RE: Taco Bell
8651 Golf Course Rd. NW
Temporary C.O. - Accepted
Engineer's Certification Date: 04/30/21
Engineer's Stamp Date: 10/16/20
Hydrology File: C12D058

Based **solely** on the Certification received 04/30/2021, this certification is approved in support of Temporary Release of Occupancy by Hydrology. **The following comments needs to be addressed prior to acceptance for Permanent C.O.**

# C4.0

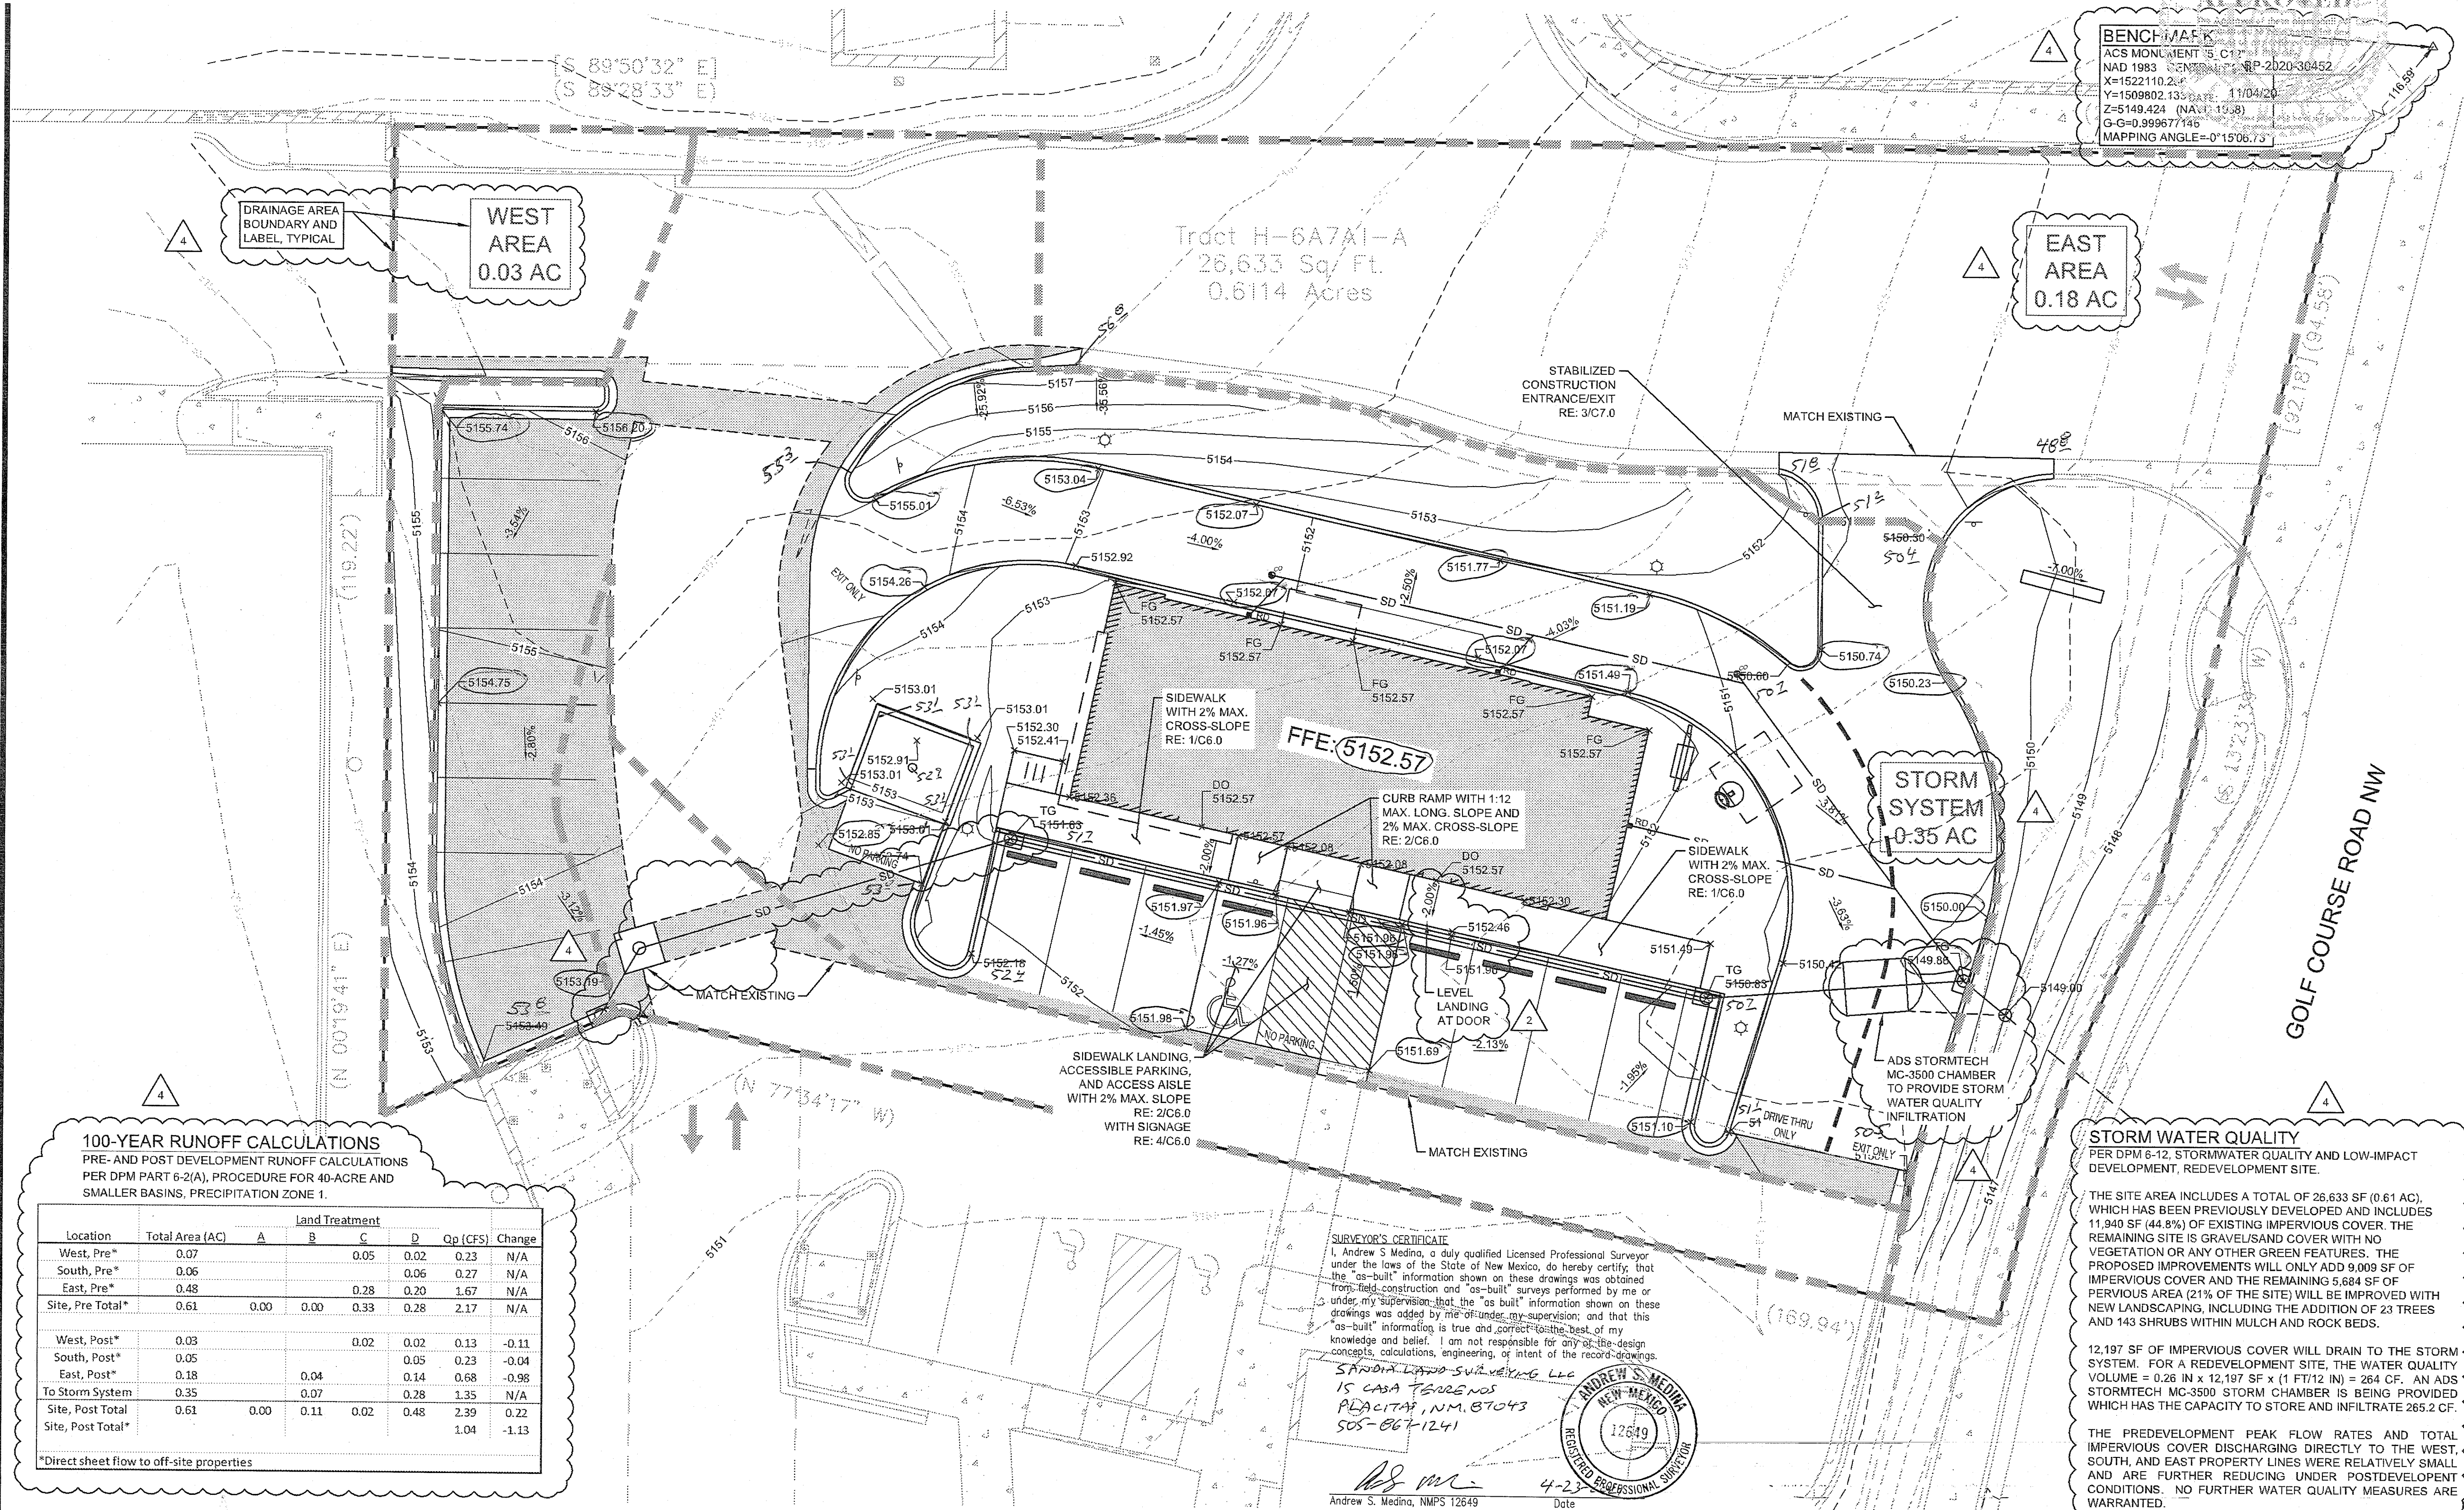
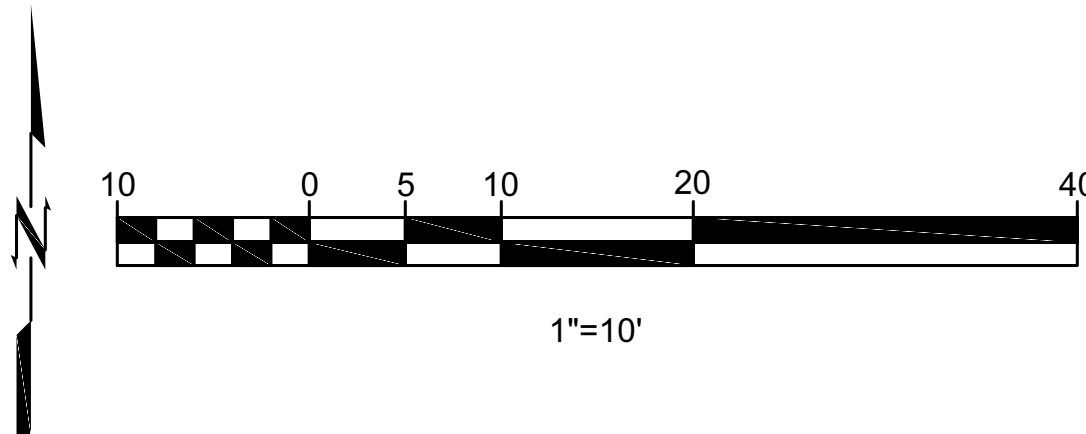
1. Please provide Drainage Covenant for the stormwater quality ponds per Article 6-15(C) of the DPM prior to Permanent Release of Occupancy. There is a recording fee (\$25, payable to Bernalillo County). Please contact Charlotte LaBadie (clabadie@cabq.gov, 924-3996). Due to COVID-19, please follow the instructions:
